***Planning Department  
Transportation Development Services***

**Re: Smith's #423 Fuel Center  
5640 4<sup>th</sup> St., NW  
Traffic Circulation Layout**  
Engineer's/Architect's Stamp dated 11-16-15 (F14-D072)

ADA Parking Sign w/Bollard

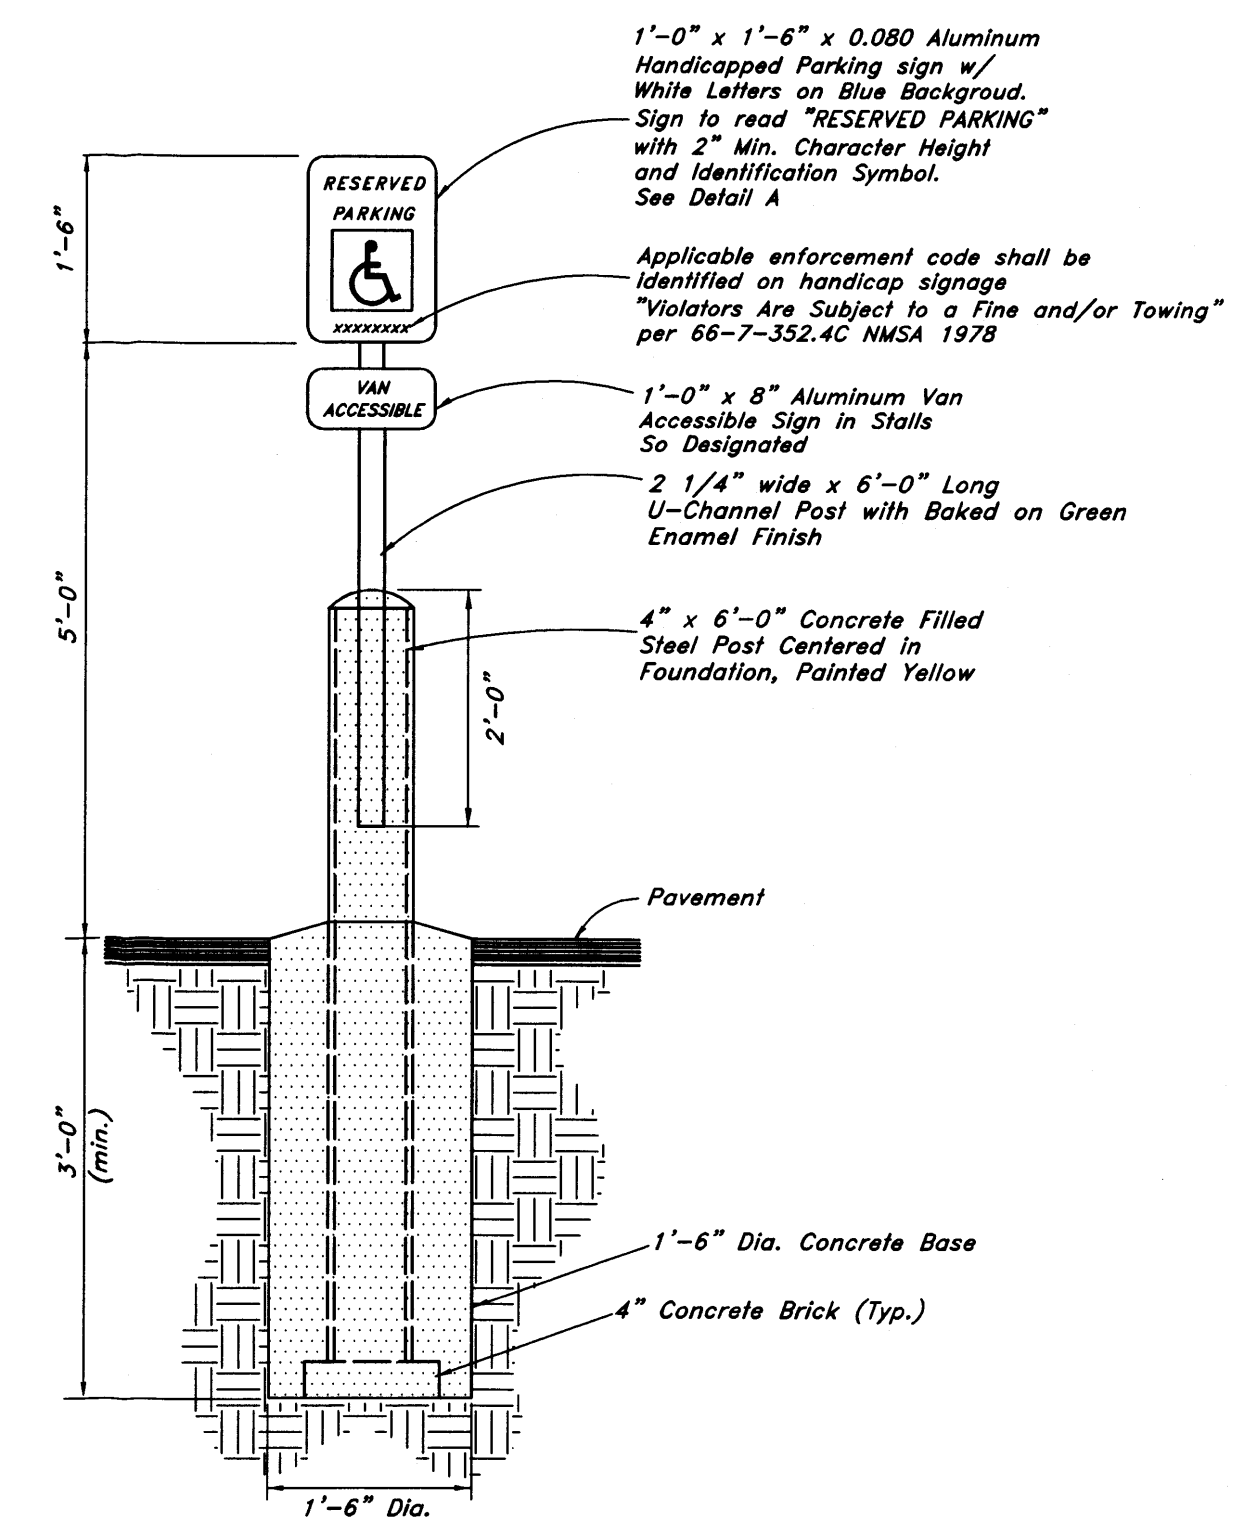
1. Identify the right of way width, medians, curb cuts, and street widths on both 4<sup>th</sup> St. and Gene Ave.
2. The ADA accessible parking sign must have the required language per 66-7-352.4C NMSA 1978 **"Violators Are Subject to a Fine and/or Towing."** Please show a detail of ADA signage.

C4.4

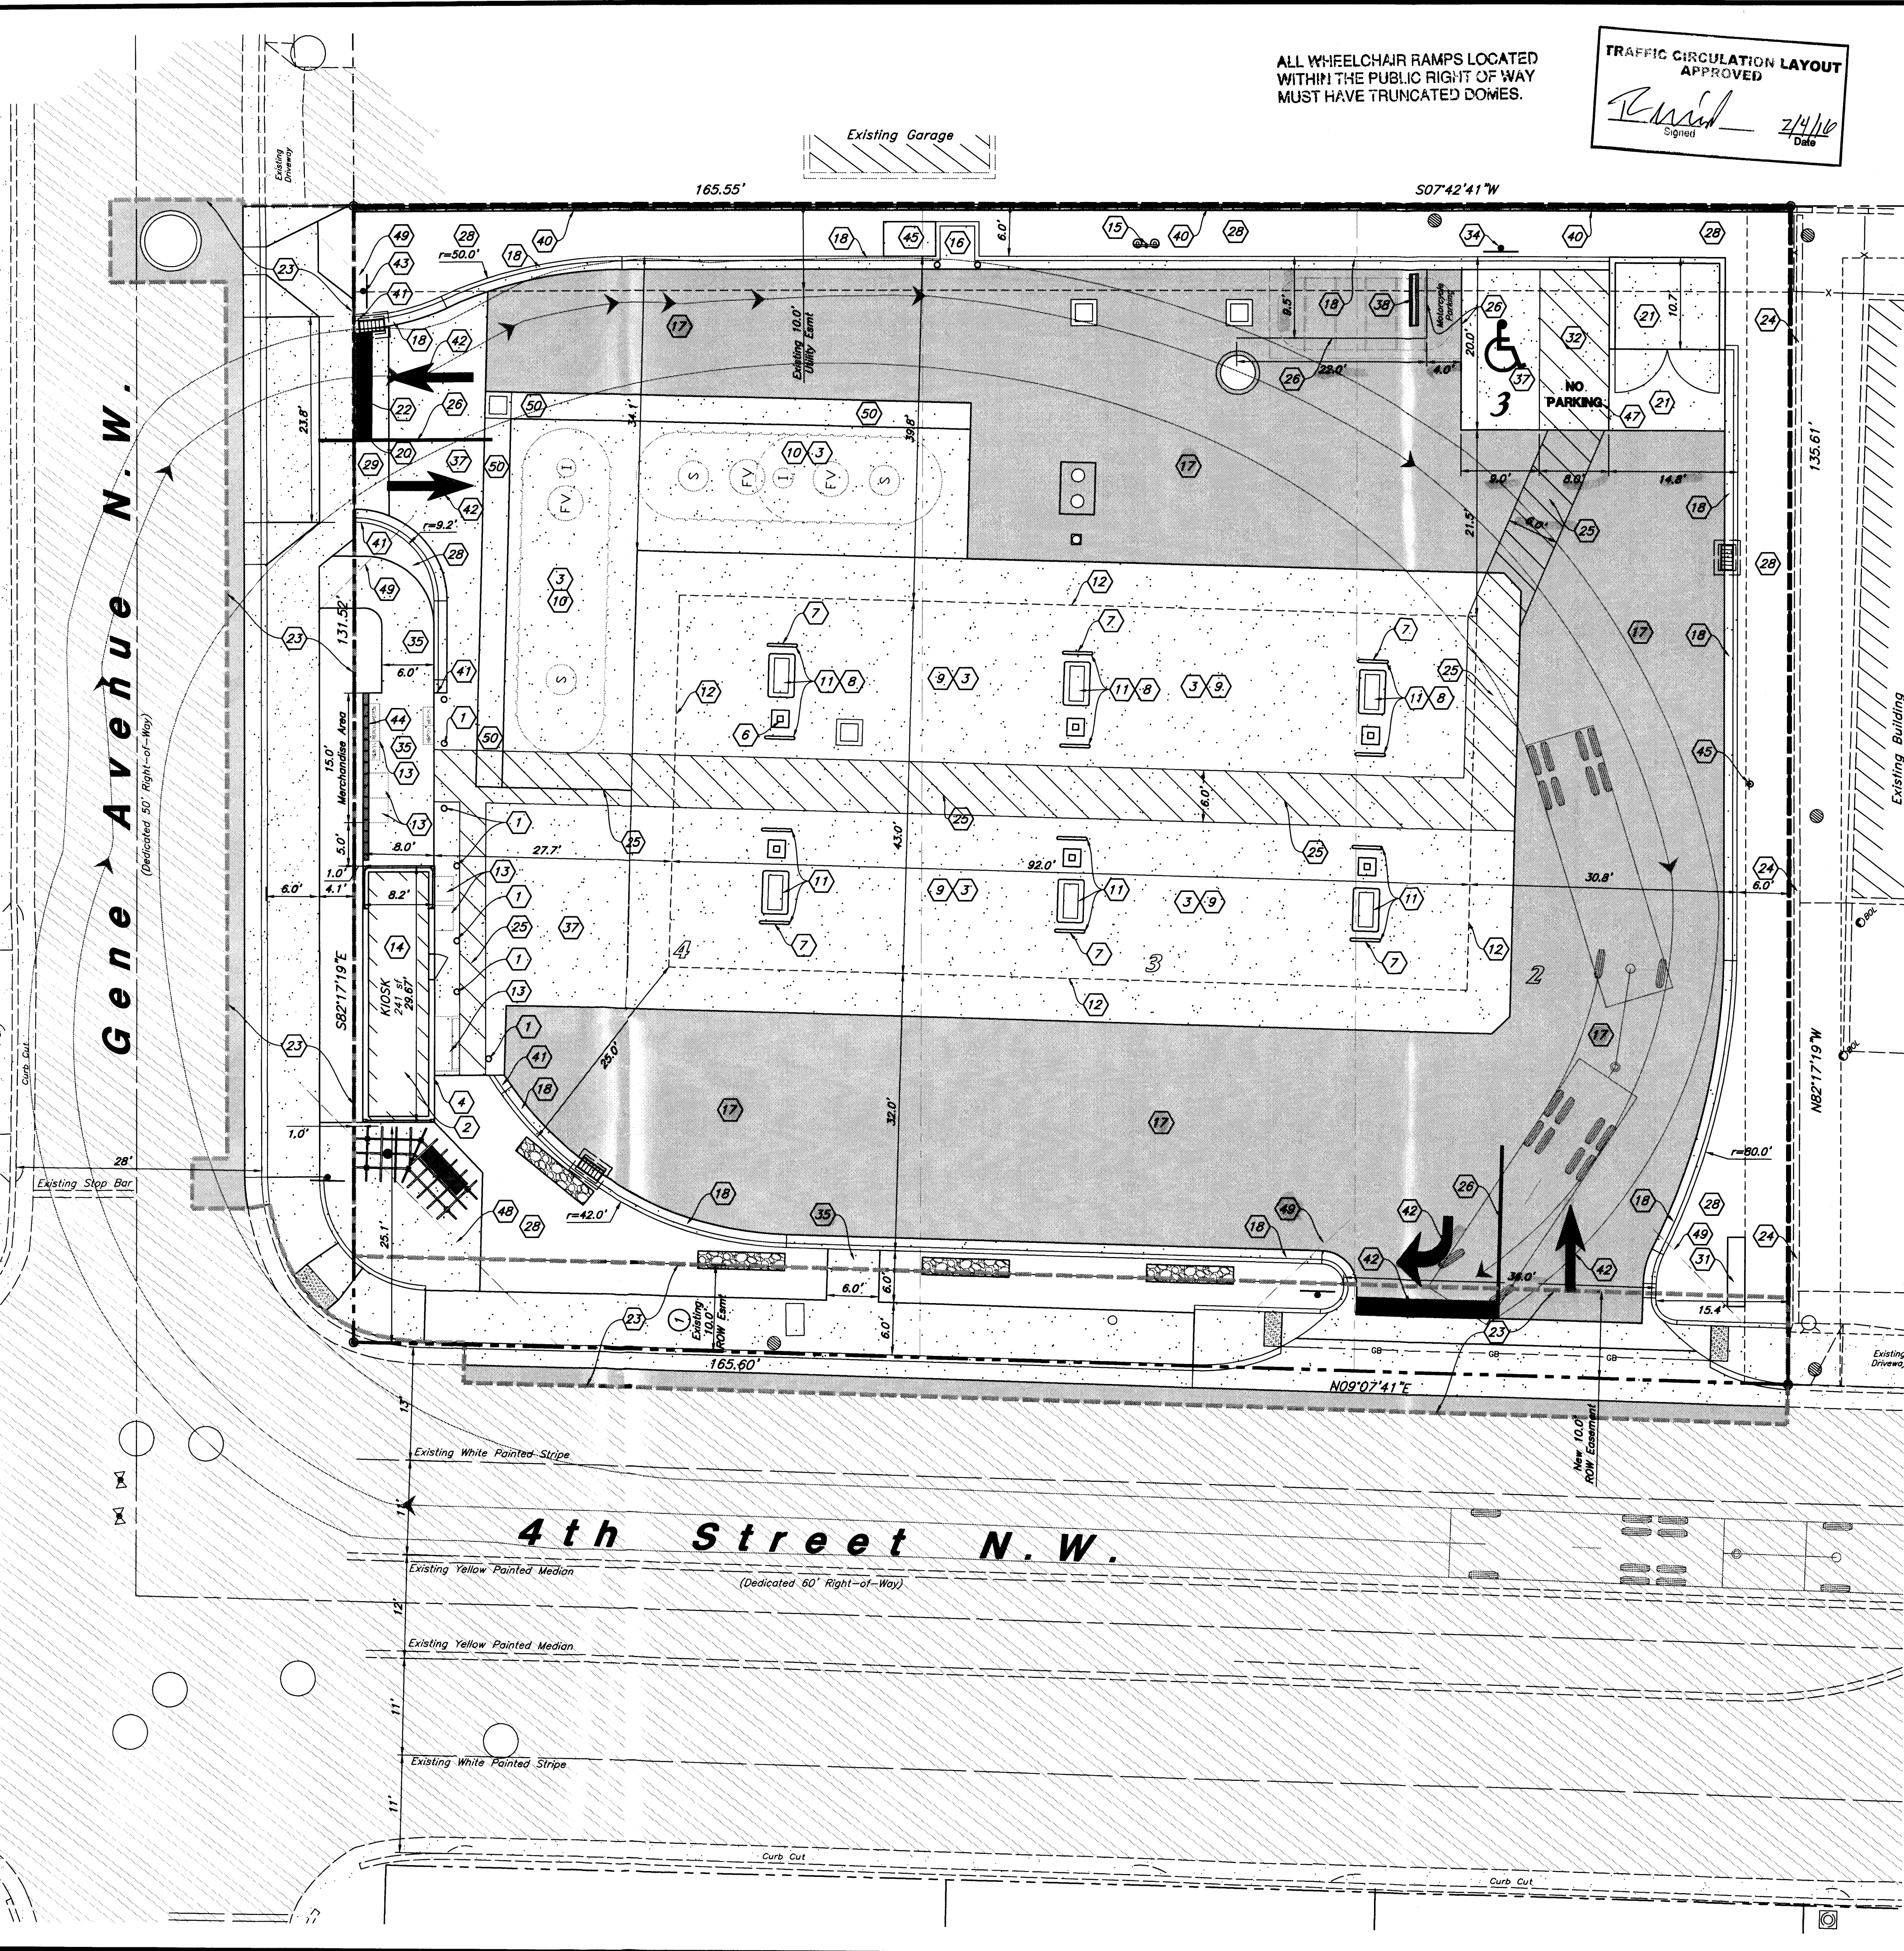
5. Detail the ADA ramps to the public sidewalk R.O.W.
6. Per the DPM, a 6 ft. wide ADA accessible pedestrian pathway is required from the HC parking stall access aisles to the building entrances. In review of submitting drawing, the proposed ADA pathway is only 4 ft. wide.

SHEET NO.
C1.1

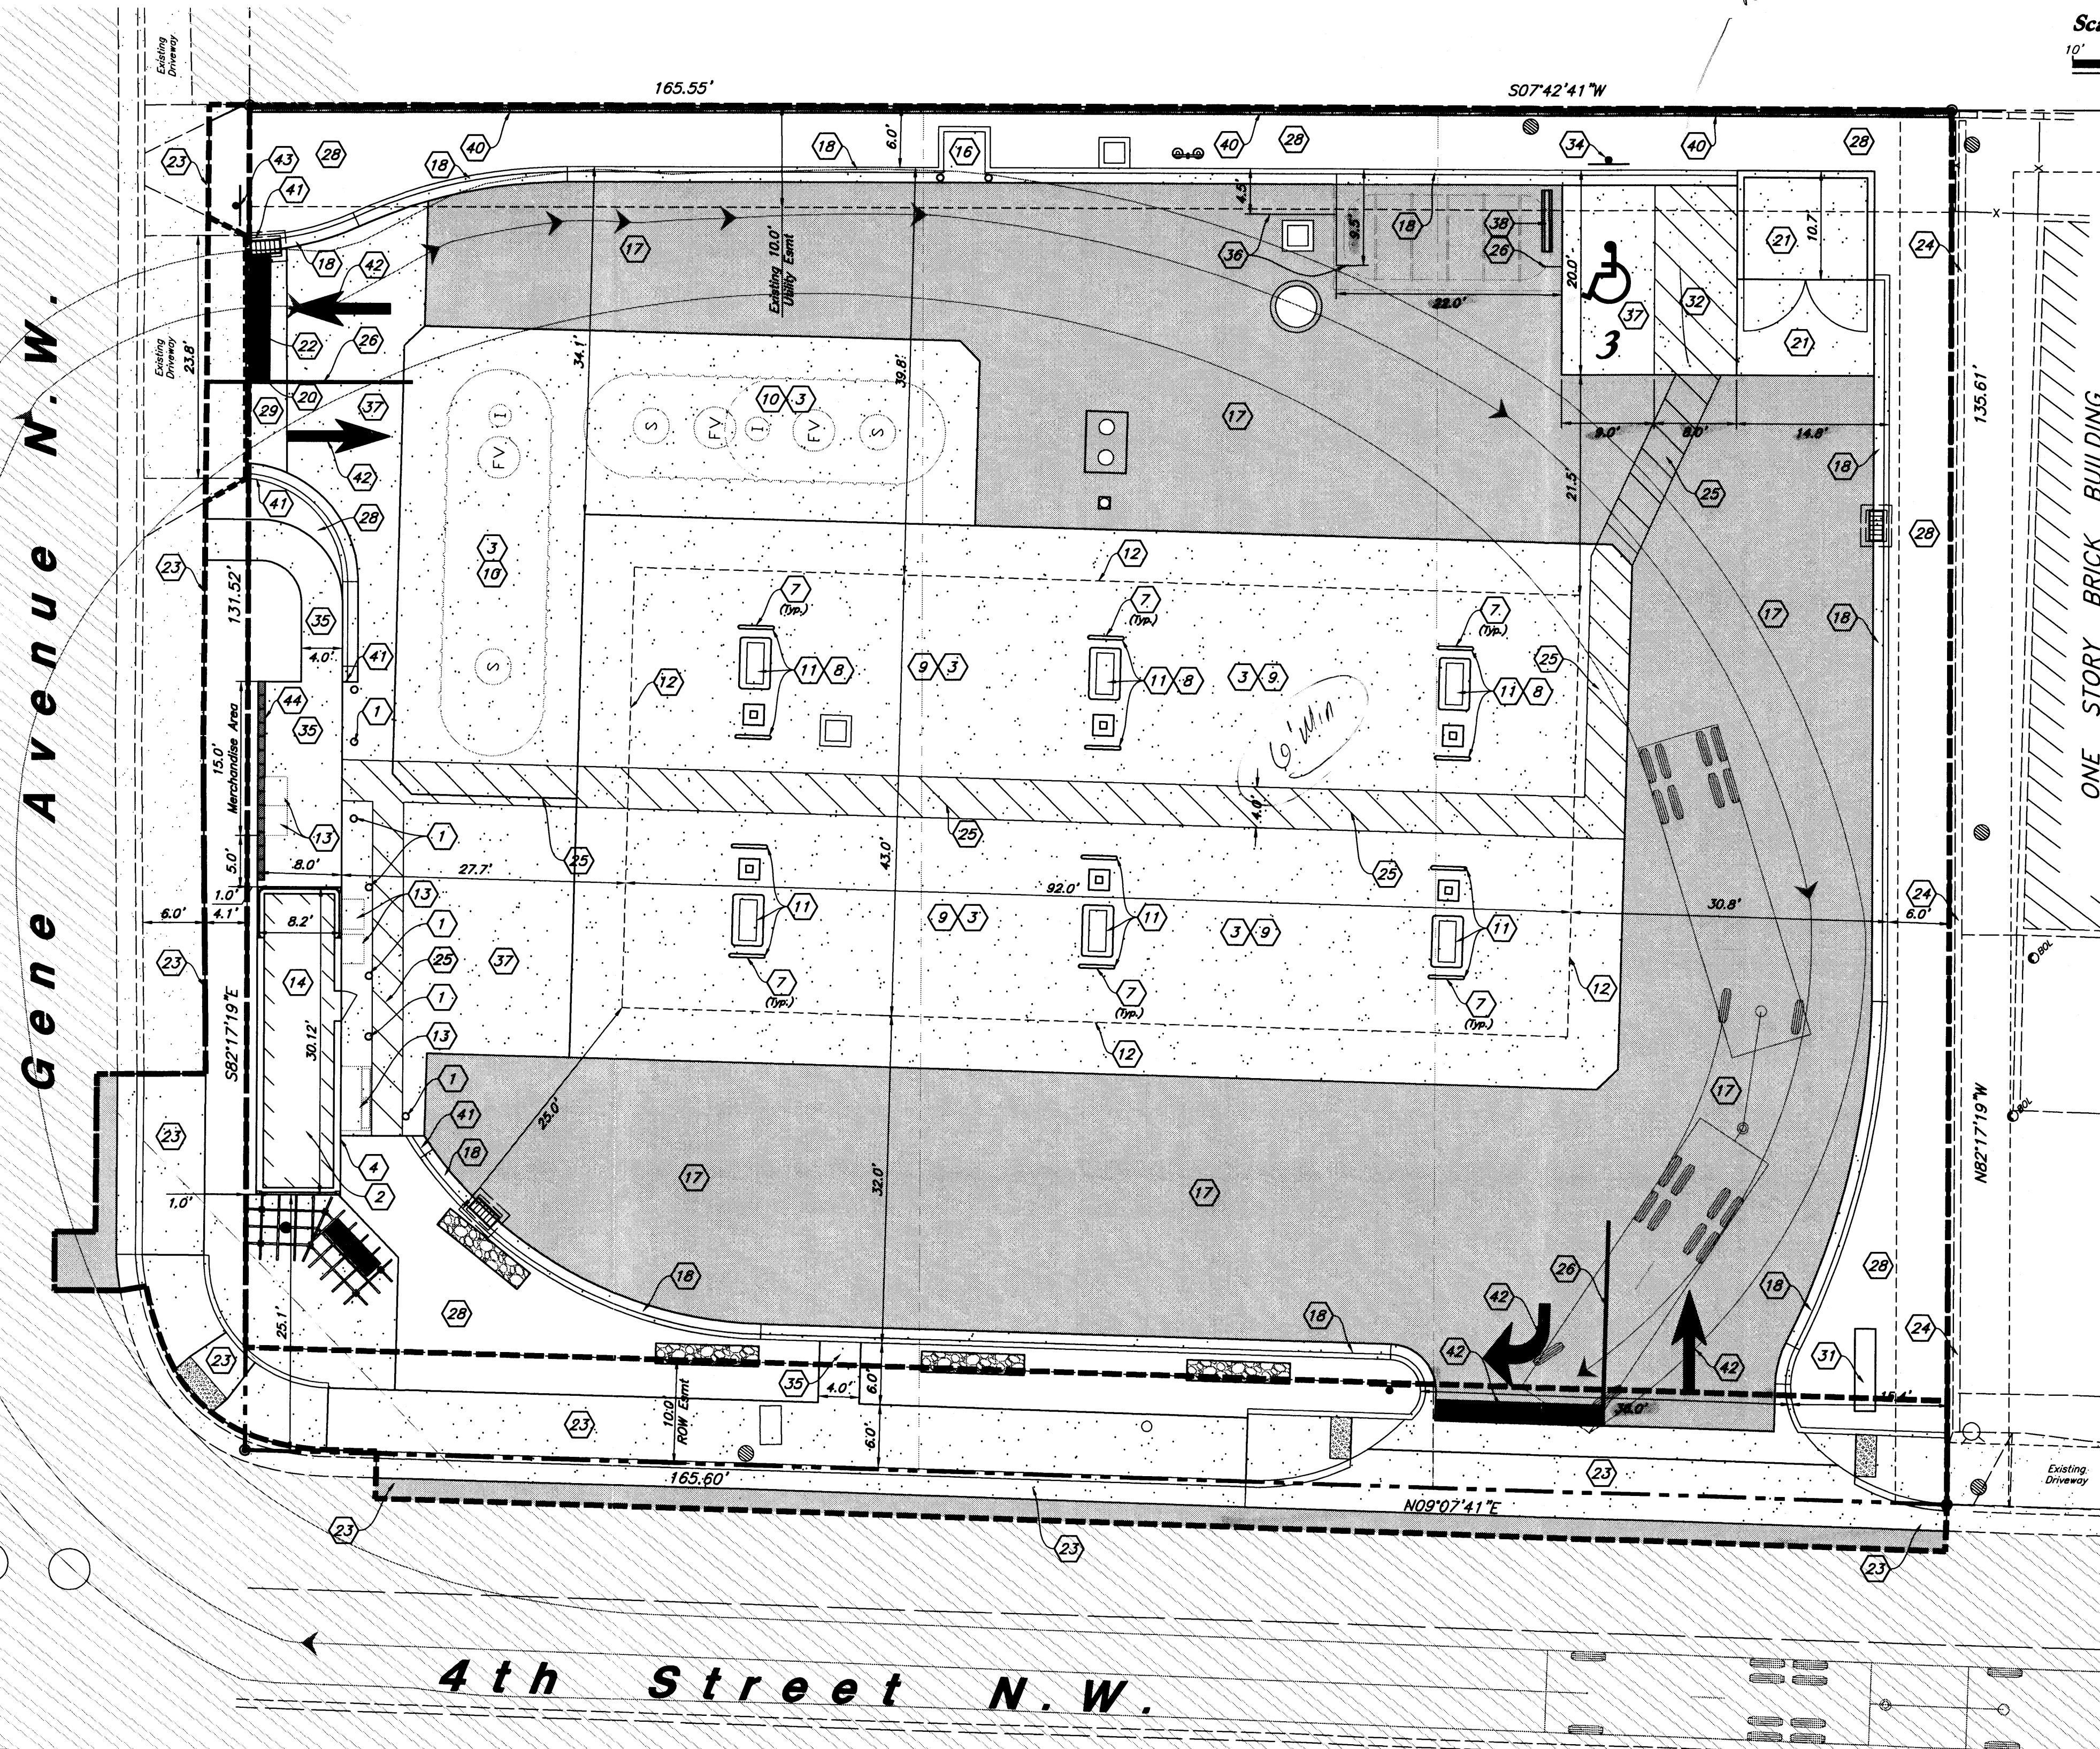
3. The ADA access aisle shall have the words **"NO PARKING"** in capital letters, each of which shall be at least one foot high and at least two inches wide, placed at the rear of the parking space so as to be close to where an adjacent vehicle's rear tire would be placed. (66-1-4.1.B NMSA 1978)

4. Per the DPM, a 6 ft. wide ADA accessible pedestrian pathway is required from the public sidewalk to the building entrances. Please clearly show this pathway and provide details from both 4<sup>th</sup> St. and Gene Ave.

7. Service vehicle and/or refuse vehicle maneuvering must be contained on-site; provide a copy of refuse approval.

8. Please provide a sight distance exhibit (see the *Development Process Manual, Chapter 23, Section 3, Part D.5 Intersection Sight Distance*). Please clearly show this detail for entrances/exits on 4<sup>th</sup> St. and Gene Ave.

9. Please add the following note to the clear sight triangle: "Landscaping and signage will not interfere with clear sight requirements. Therefore, signs, walls, trees, and shrubbery between 3 and 8 feet tall (as measured from the gutter pan) will not be acceptable in this area."
10. Please include two copies of the traffic circulation layout at the next submittal.
